Recommendation Report for Planning Permission

REF NO: BE/44/25/PL

LOCATION: Land adjacent to 21 Greencourt Drive
Bersted
PO21 5EU

PROPOSAL: 2 x No. 2 bedroom detached bungalows with associated car parking and bin and bike stores (resubmission following BE/70/24/PL). This application is in CIL Zone 4 and is CIL Liable as new dwellings.

5.1 *Proposed Foul Water Drainage Strategy*

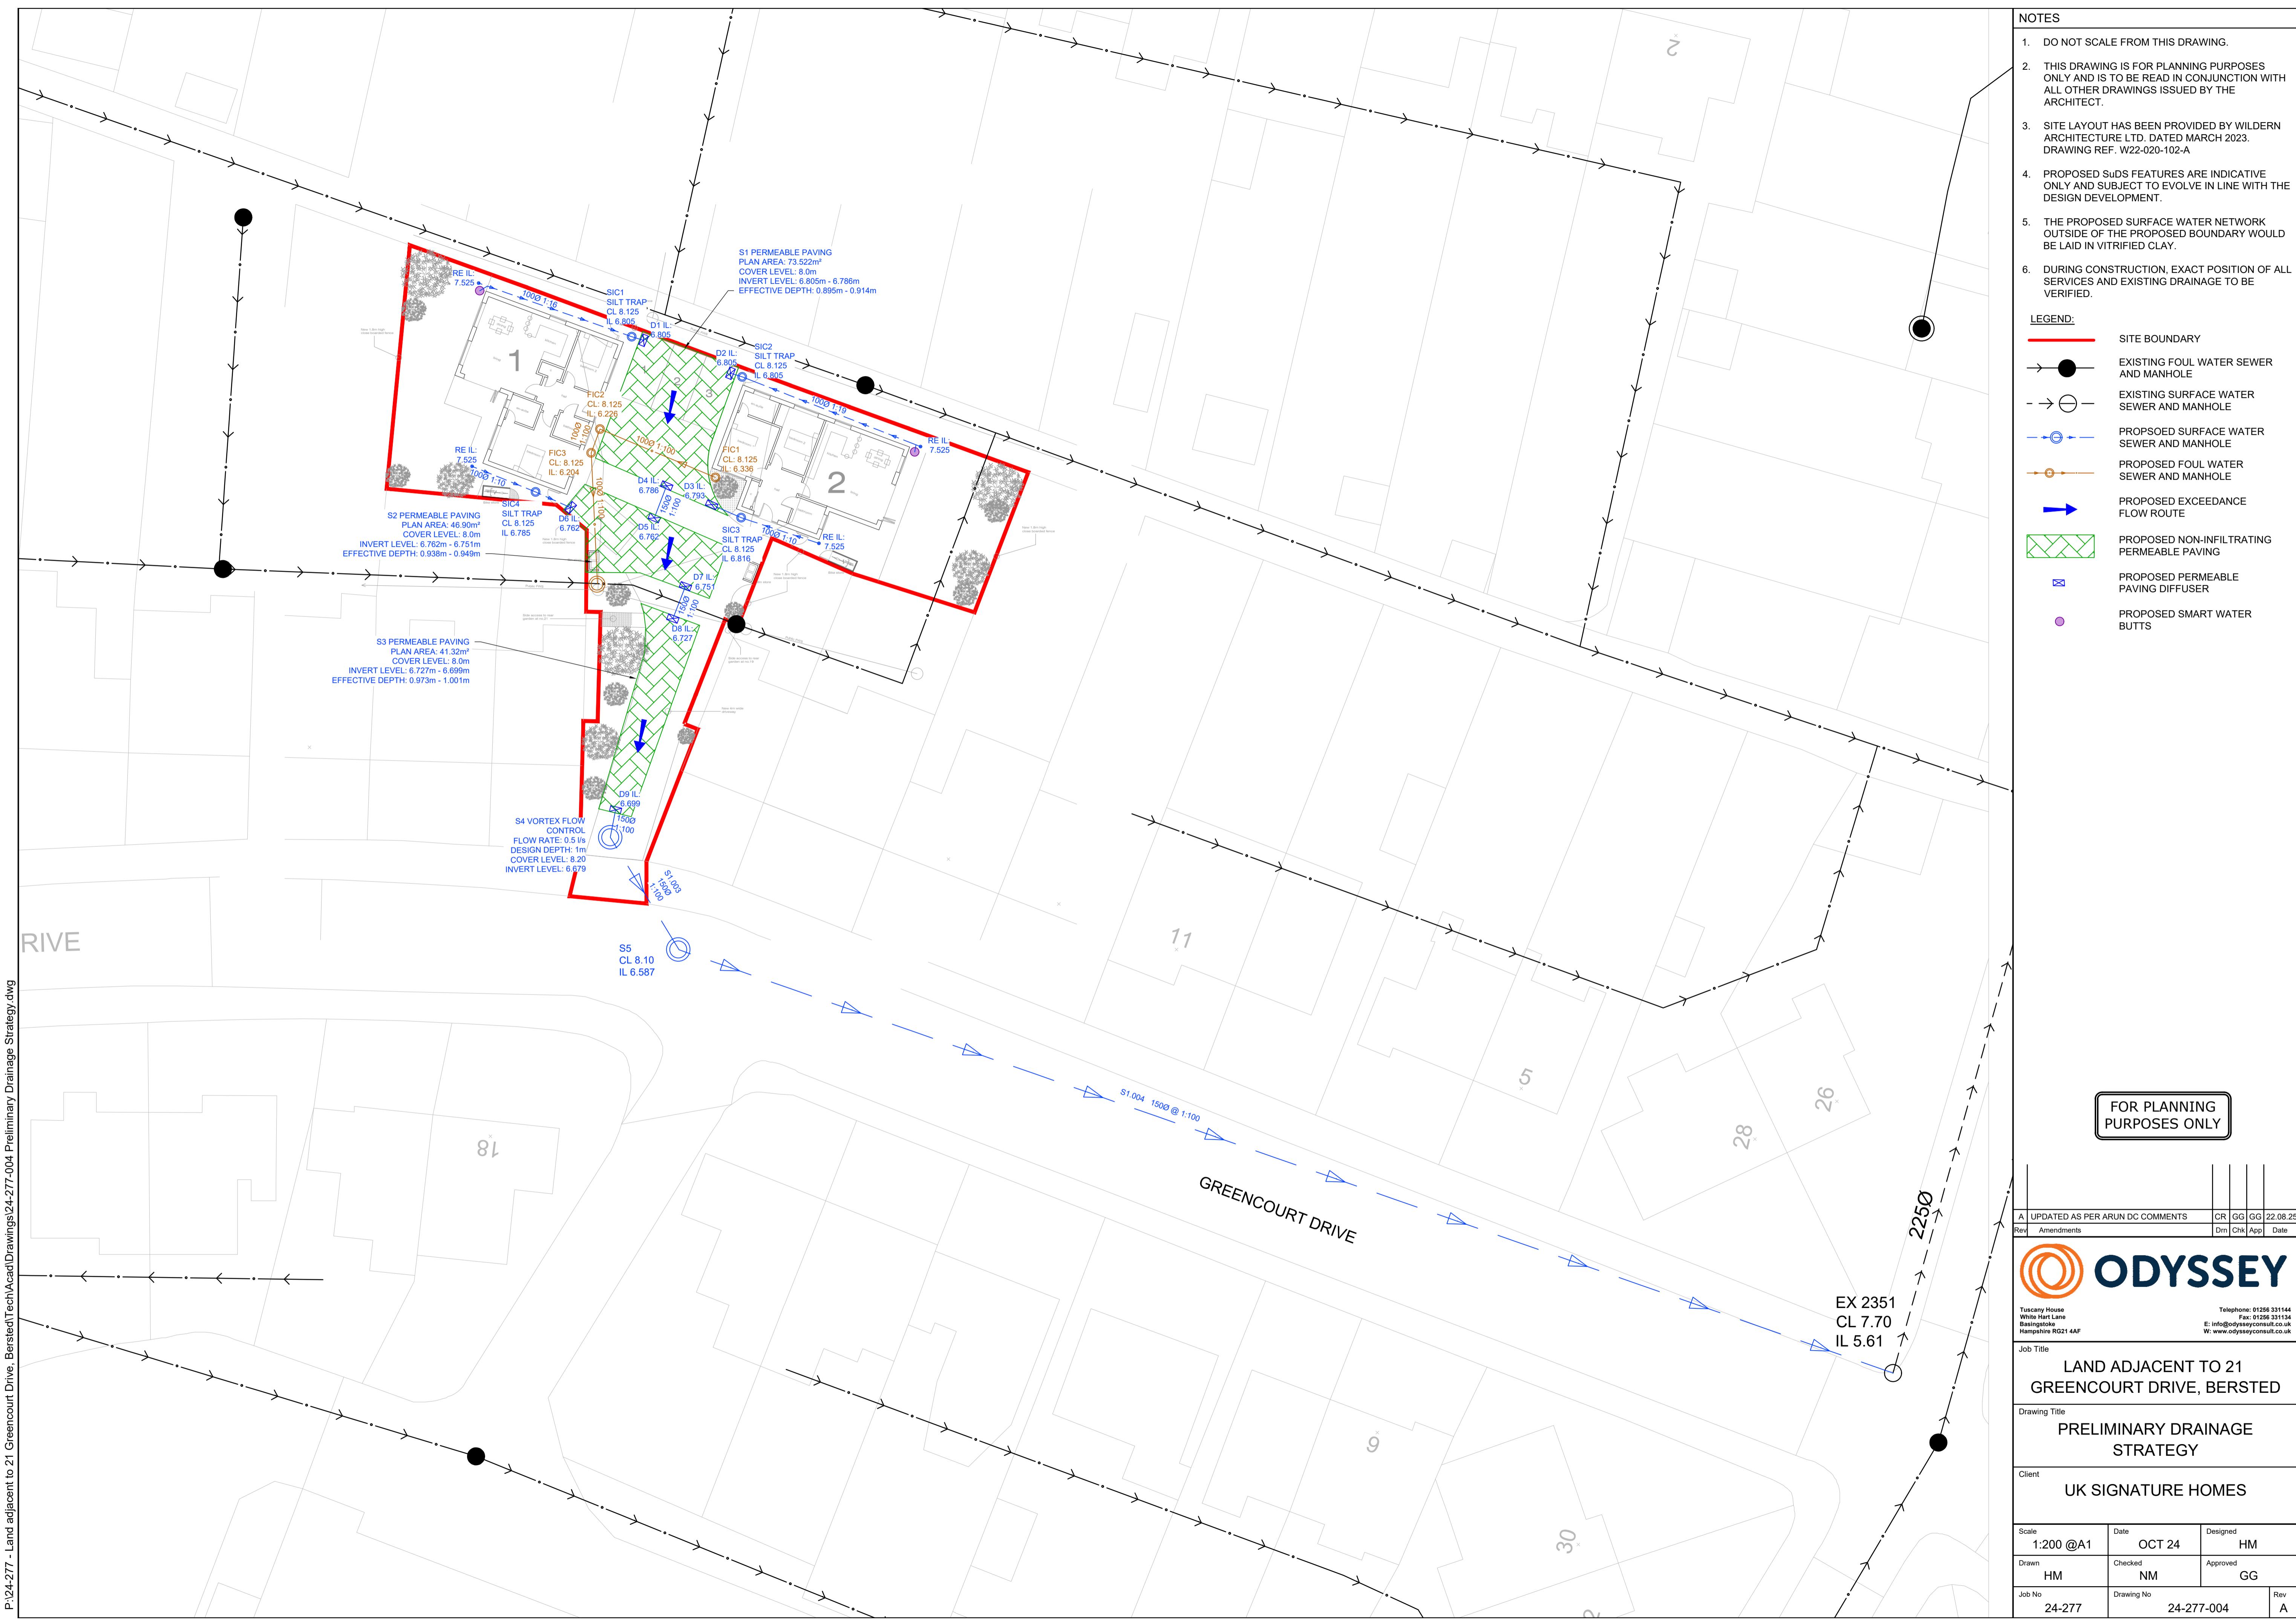
This strategy has been reviewed and assessed by the ADC Drainage Engineers, and they object to the scheme. This is due to a number of issues (some which require minor amendment), but of which there are two major issues. A second consultation has been undertaken following receipt of further information, however the original objection is sustained:

- There will be a considerable length of 'offsite' pipework and associated manhole/s. Confirmation is required as to whether these assets are to be adopted by a Water Company. Evidence of agreement in principle from the Water Company will be required. It is unlikely, that West Sussex County Council (WSCC), as Highway Authority will permit an unadopted arrangement in the public highway and therefore it is important to establish its future status. If adoption is not sought, then confirmation will be required from WSCC that the principle of the arrangement is acceptable to them.
- Insufficient information has been provided in respect of hydraulic calculations and modelling. Further data and modelling is required.

Evidence of permission in principle from Southern Water is also required in respect of the proposed connection of the surface water to the Public Surface Water; and an issue regarding the location of an existing manhole between Greencourt Drive and South Way remains unresolved.
